NE 1/4 OF THE NE 1/4 OF SECTION 25, T11S, R66W OF THE 6TH P.M.
EL PASO COLORADO

SUNDANCE WEST MAP AMENDMENT (REZONE)

SUNDANCE WEST MAP AMENDMENT (REZONE)

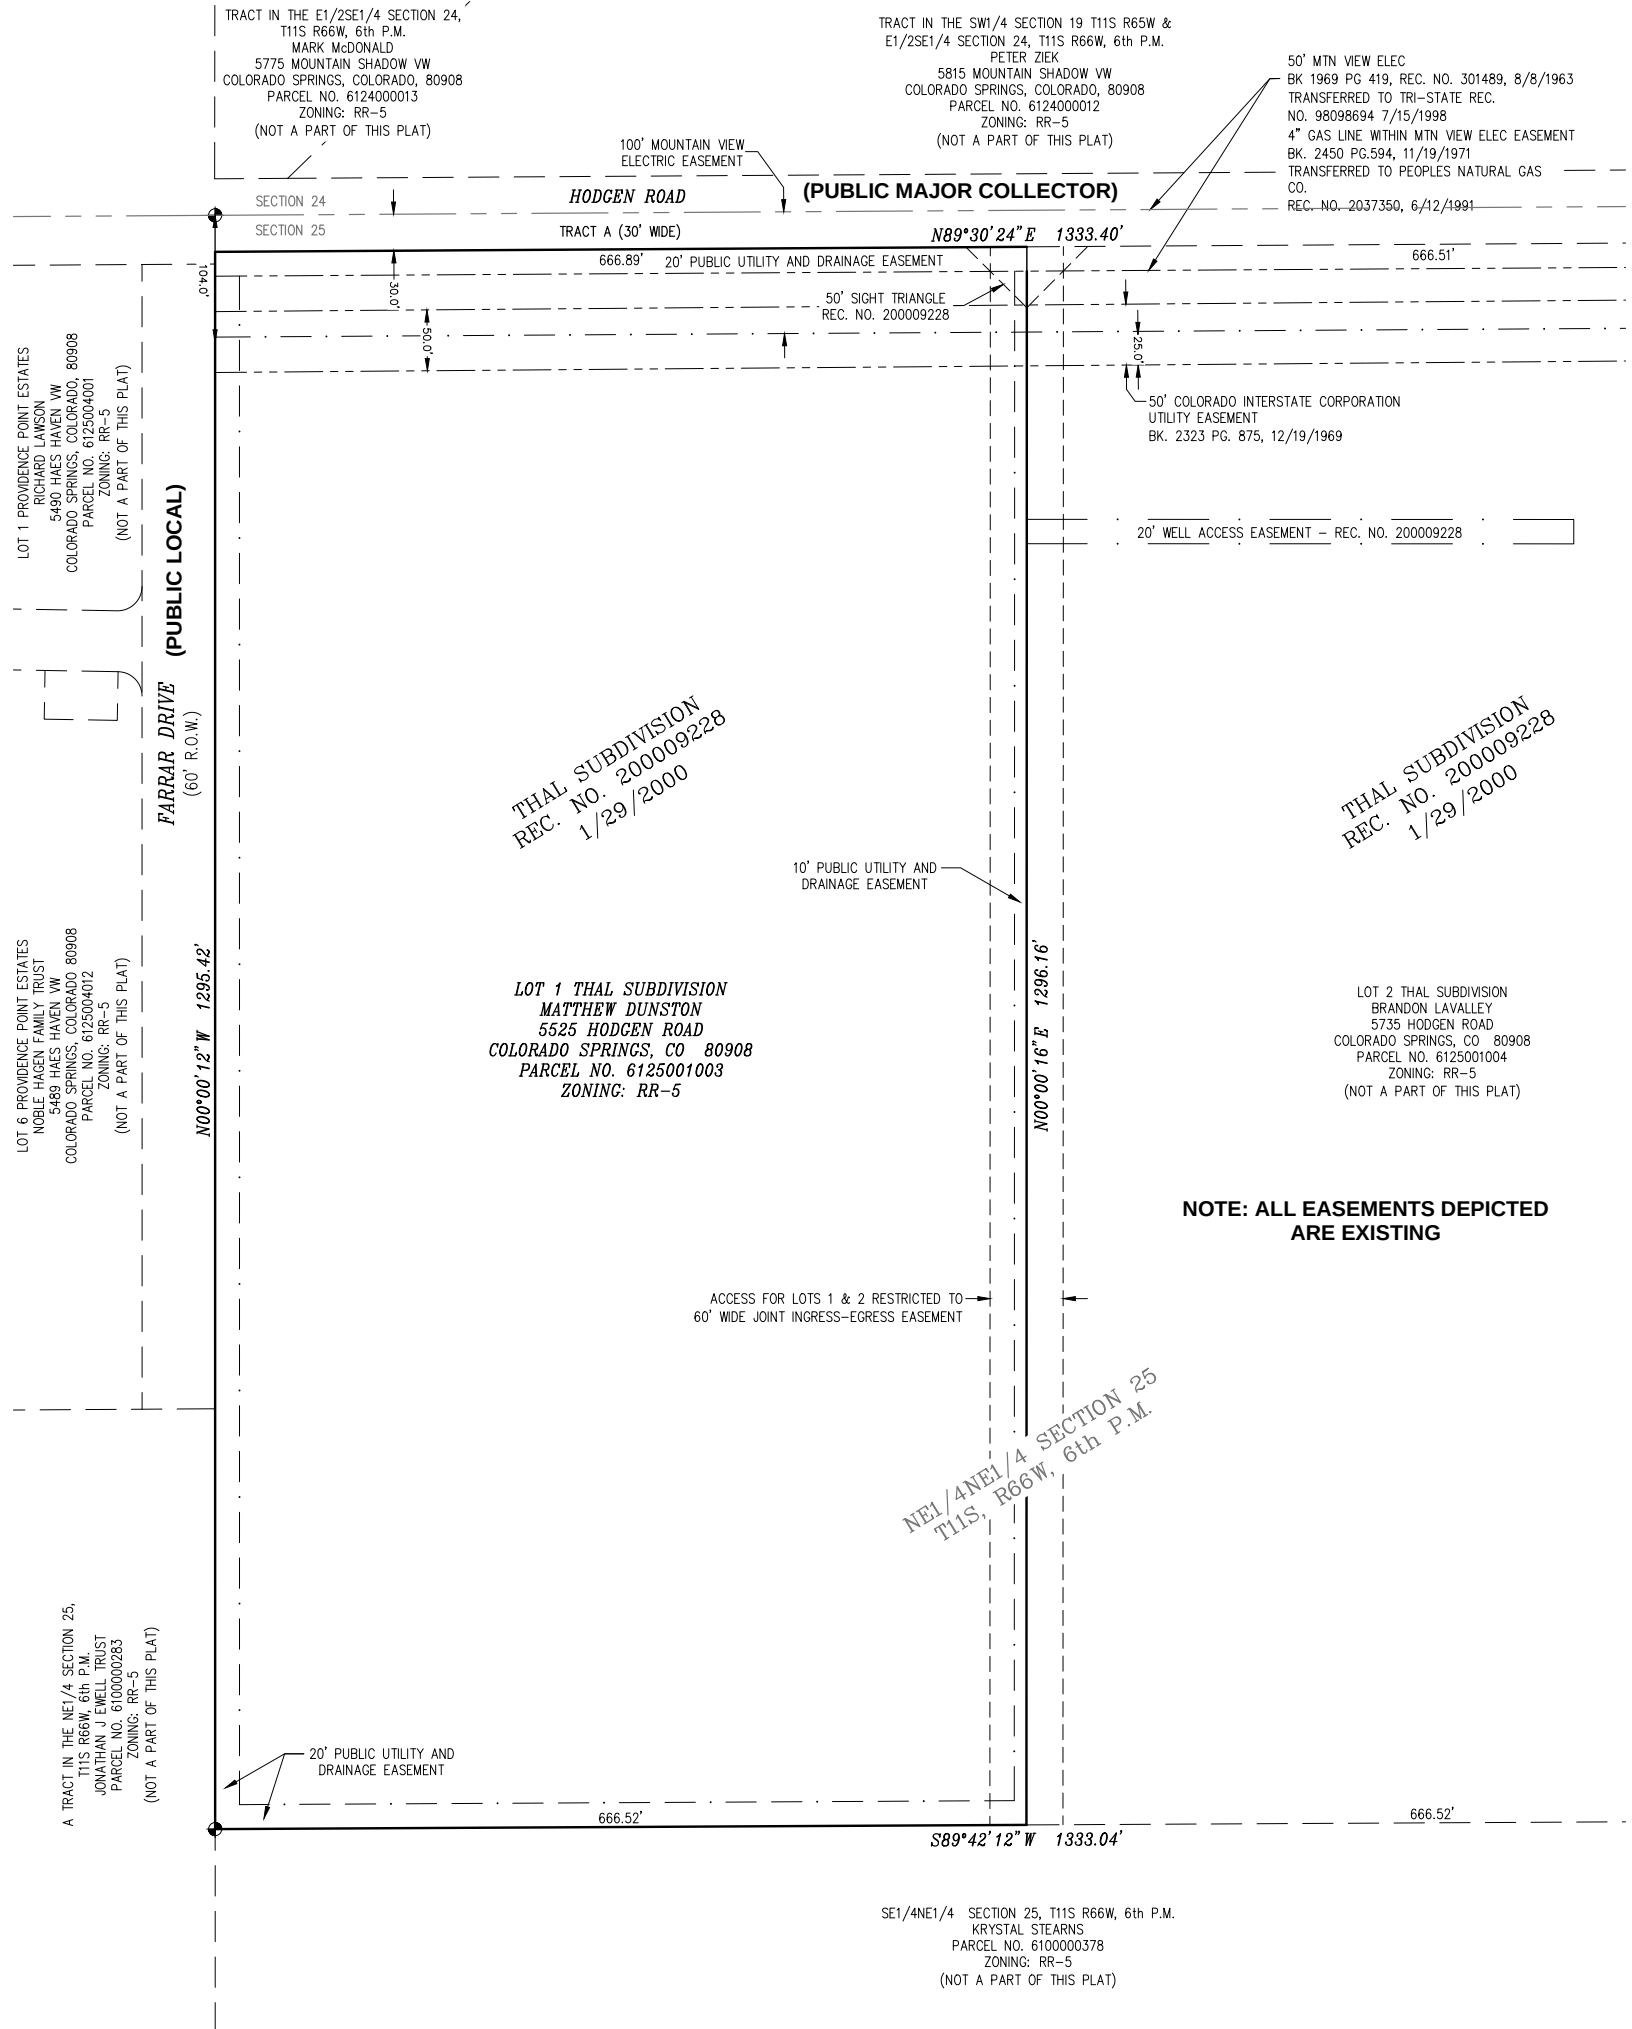
Rezone should reach to the center line of Hodgen Road.

If all easements shown on this map are existing, please add a note to that effect.

Informational Note:
Access for this subdivision is proposed for Farrar Drive. The 30' of the easement on lot 1 may be vacated under the final plat application.

RESPONSE: PER COMMUNICATION WITH PLANNER, THIS COMMENT CAN BE IGNORED

RESPONSE: ADDED

RESPONSE: UNDERSTOOD
